CITY OF ALBUQUERQUE

April 11, 2014

RE: **614 First Street Parking Lot Improvements**
Grading & Drainage Plan for Grading and Paving Permit, and SO-19

Based upon the information provided in your submittal received 4/2/14, the subject Grading and Drainage Plan cannot be approved for Grading or Paving Permit, or SO-19.

GRADING AND DRAINAGE PLAN

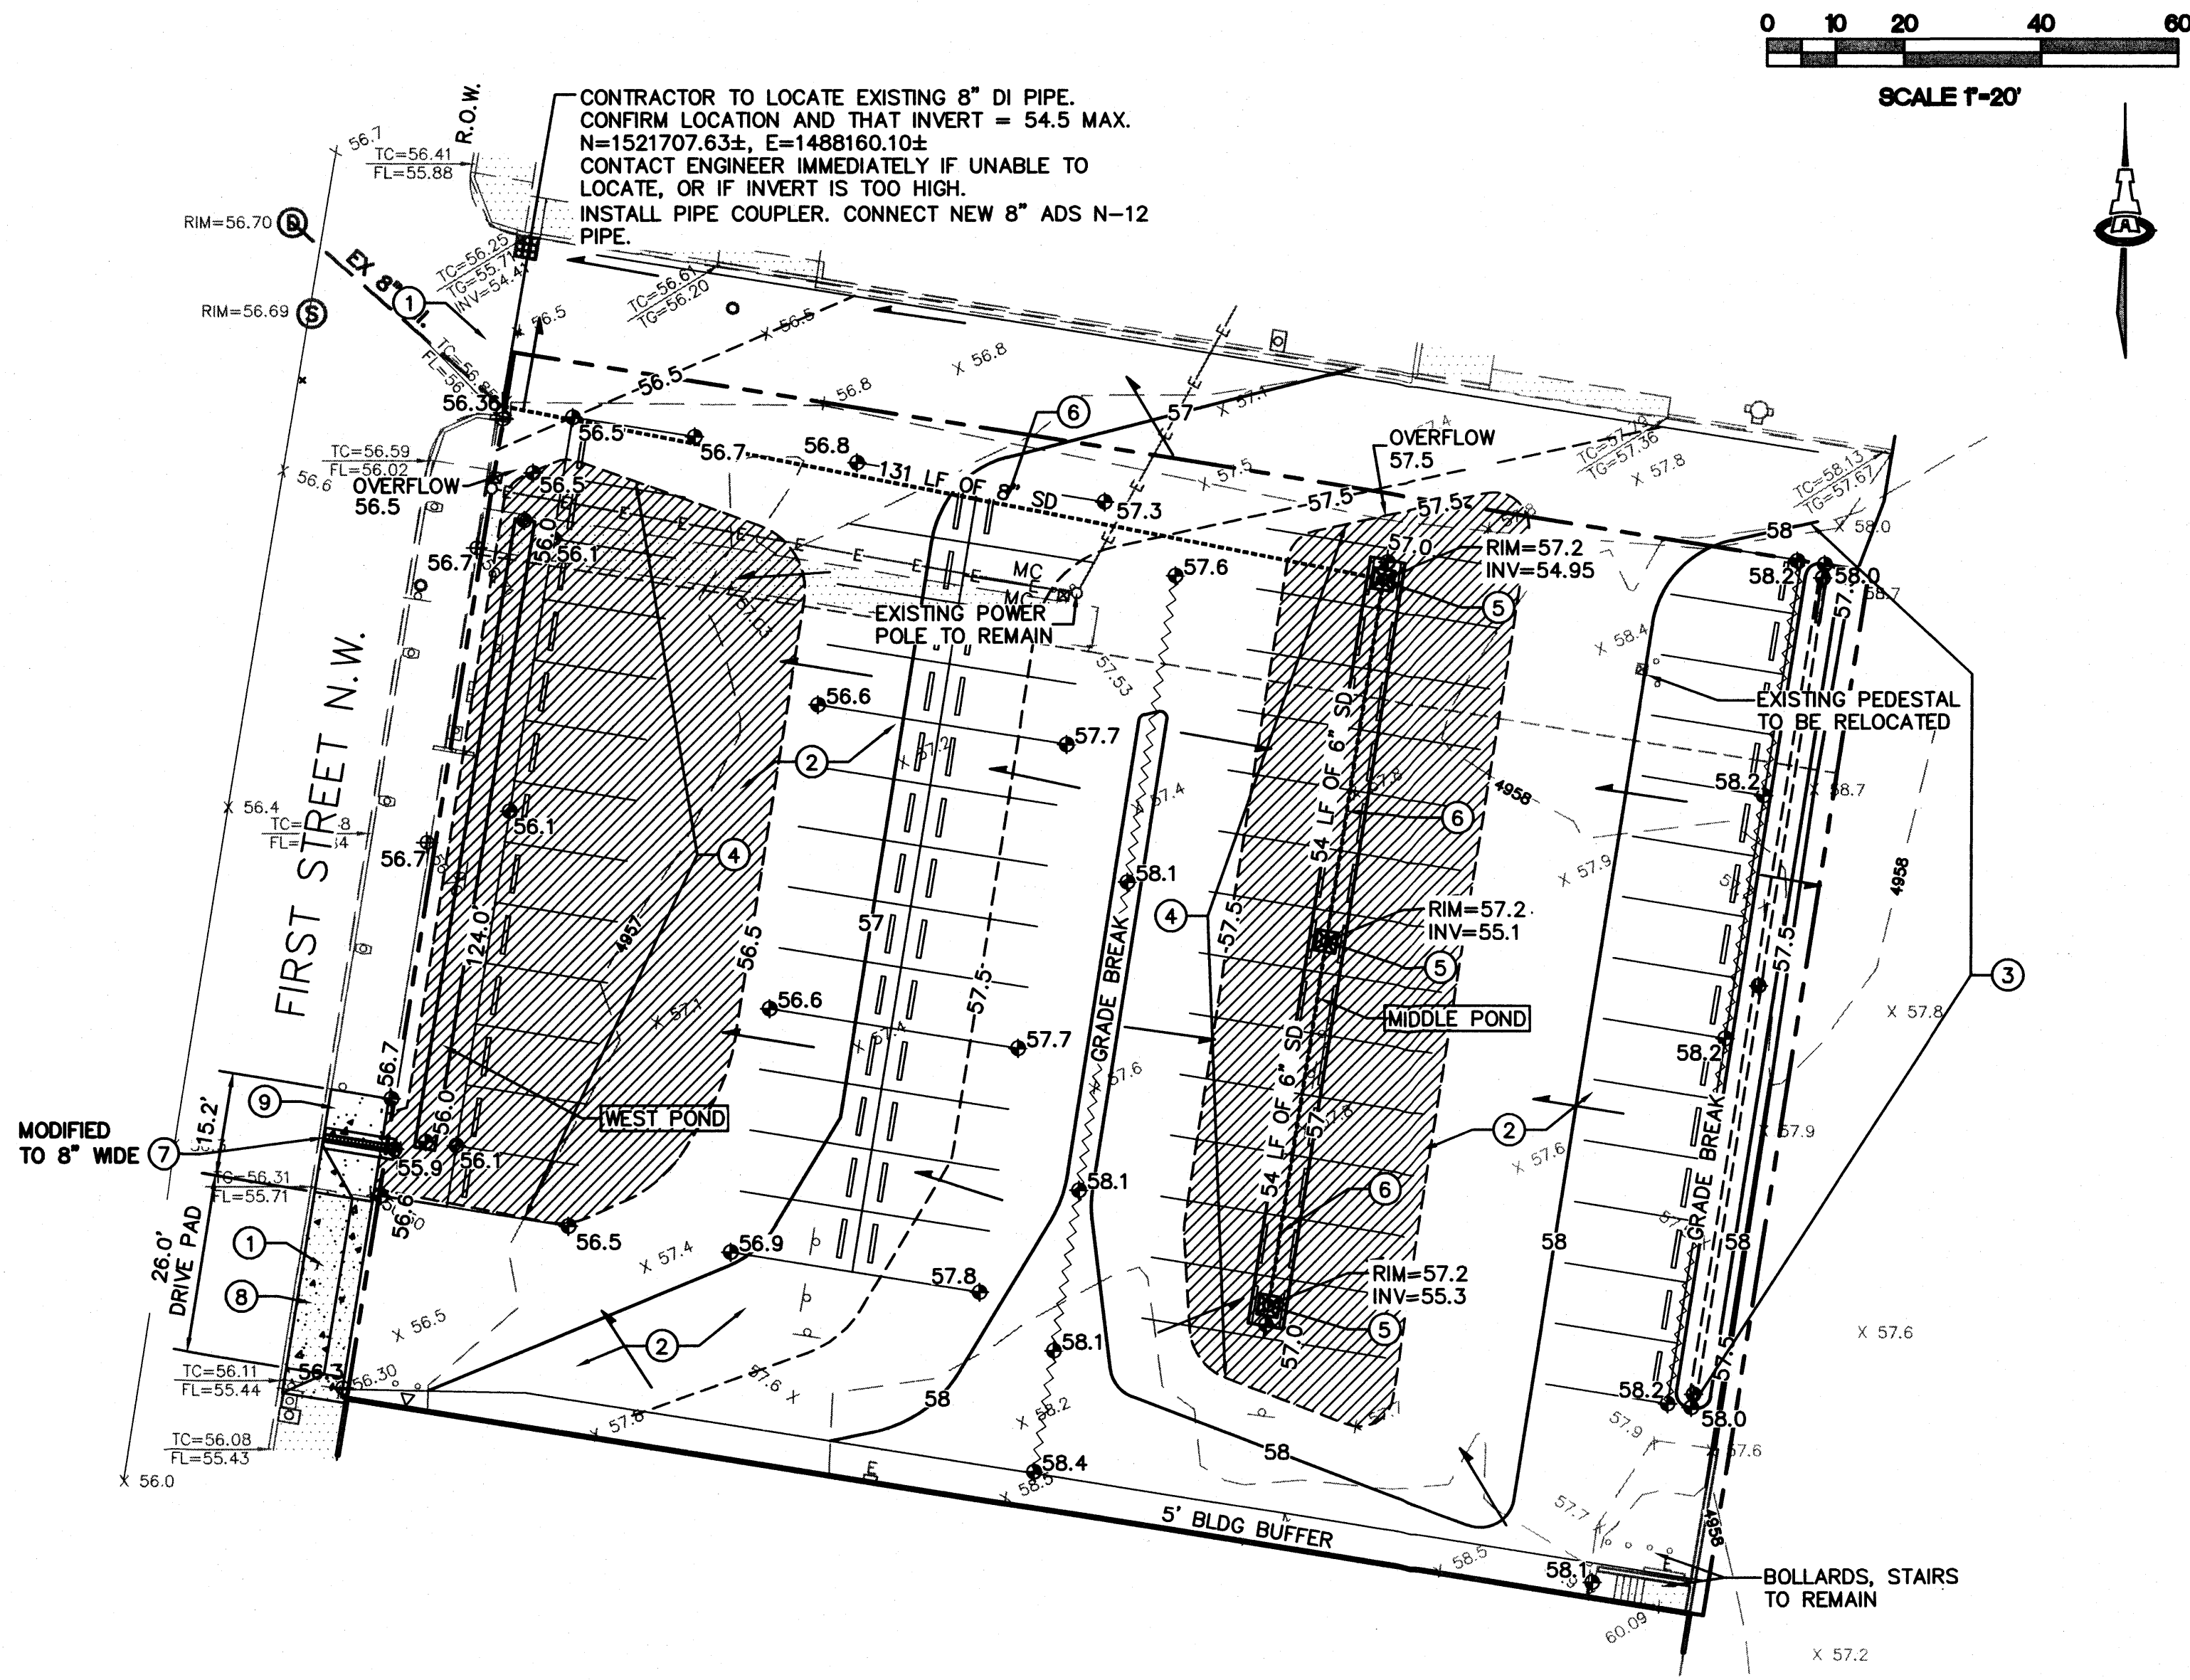
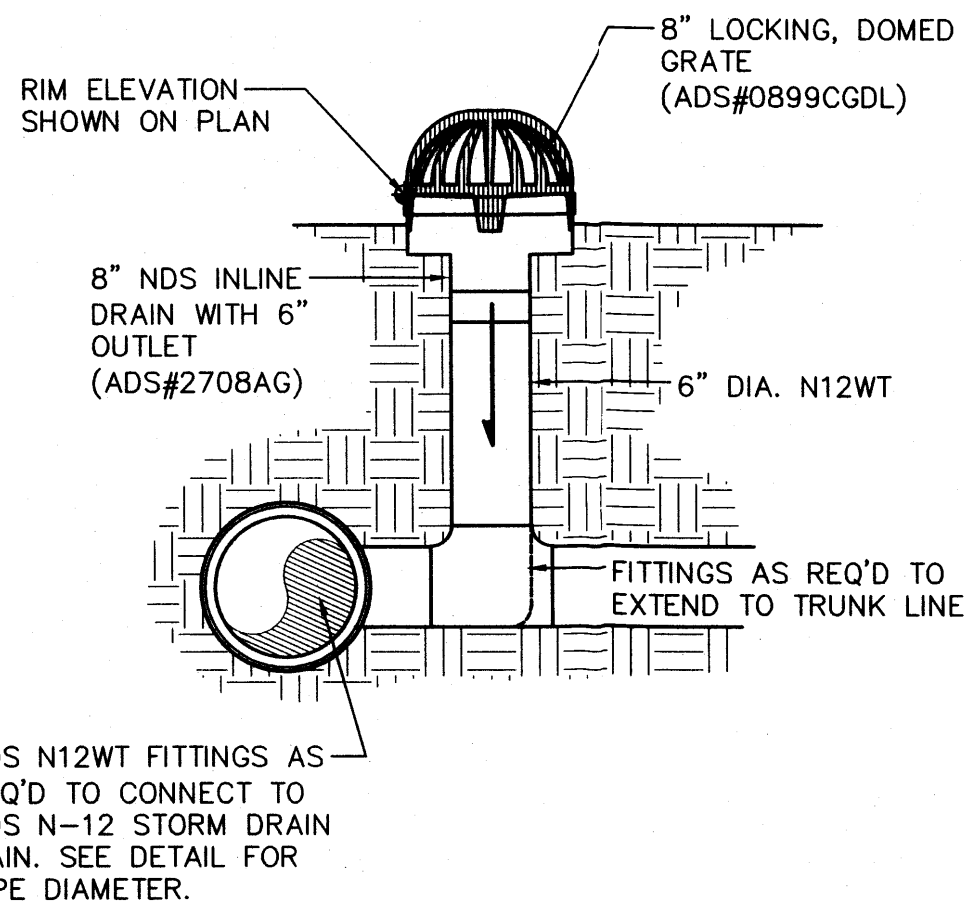
- PO Box 1293
- Albuquerque
- New Mexico 87103
1. Show on the plan the location (known or believed) for the existing storm drain lines in First Street, the particularly the proposed outfall for the east middle pond.
 2. Dimension the expected location of the existing 8" DI pipe at NW entrance.
 3. Build note 5 should be removed from the existing inlet on the north side of the NW entrance.
 4. Build Notes 8 & 9 are reversed on the plan at the SW entrance.
 5. Extend the sidewalk culvert 2' beyond back of sidewalk, and add the note to weld the bolts to the plate.
 6. Site calculations assume detention in the onsite ponds. Provide calculations and the necessary restriction details to demonstrate that the two ponds only discharge 1.96 cfs, or about 0.98 cfs each. .
